August 29, 2017

**Subject: Onejoy Place
Revised Plans & Additional Information**

SHEET DESCRIPTION  
**ONEJOY PLACE**  
1 JOY PLACE, PORTLAND, MAINE 04102  
**SITE LAYOUT PLAN**

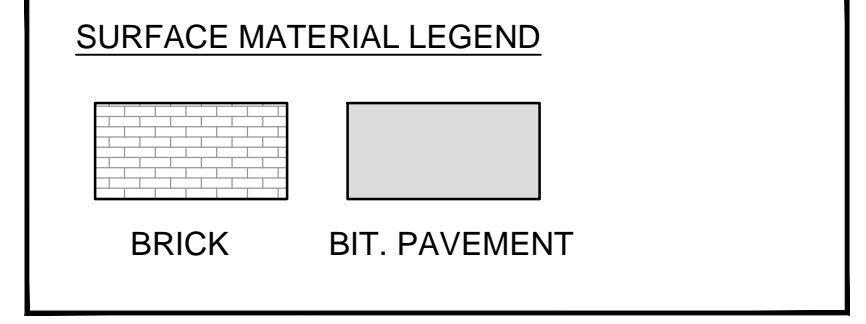
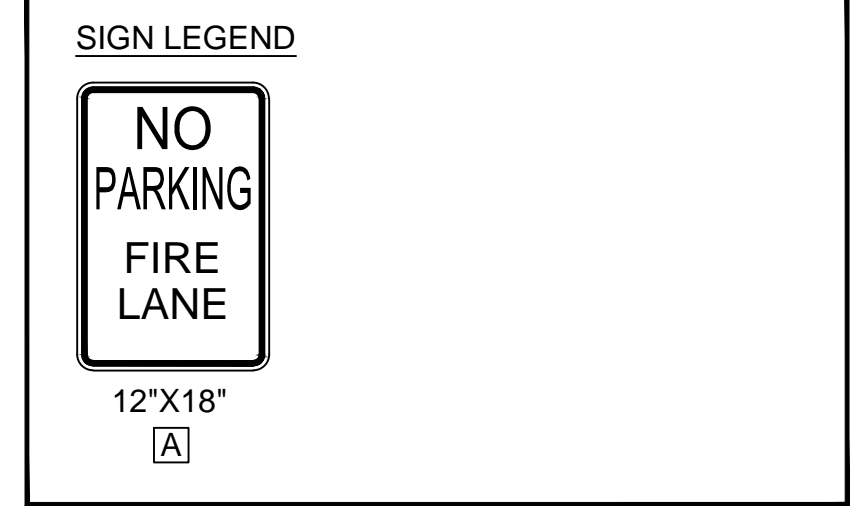
1. The previously proposed sidewalk located on the 157 Brackett Street parcel has been removed from the plan. A 5' wide brick surface will be installed on the south side of the Joy Place right-of-way, and three flush planting beds will be constructed within the brick surface. Each planting bed will feature a tree and low-growing ground cover plantings. A total of six precast concrete light bollards will be installed on either side of the planting beds in place of the previously proposed light poles. The flush brick surface treatment will indicate a walking path for pedestrians, but will still be available for vehicles to maneuver.

The clear width of Joy Place will remain similar to the previously proposed plan with the exception of three trees that will be installed within 20" of the southern property boundary and the six light bollards that will be installed on the property boundary. The clear width will be a minimum of 21.5' at the tree locations.

3. The two bike hitches previously proposed to be located at the end of the sidewalk between Joy Place and 157 Brackett Street have been relocated to the north side of the building, in the vicinity of the solid waste and kayak storage.

Reference: Plan Sheet C-3.0 Site Layout Plan
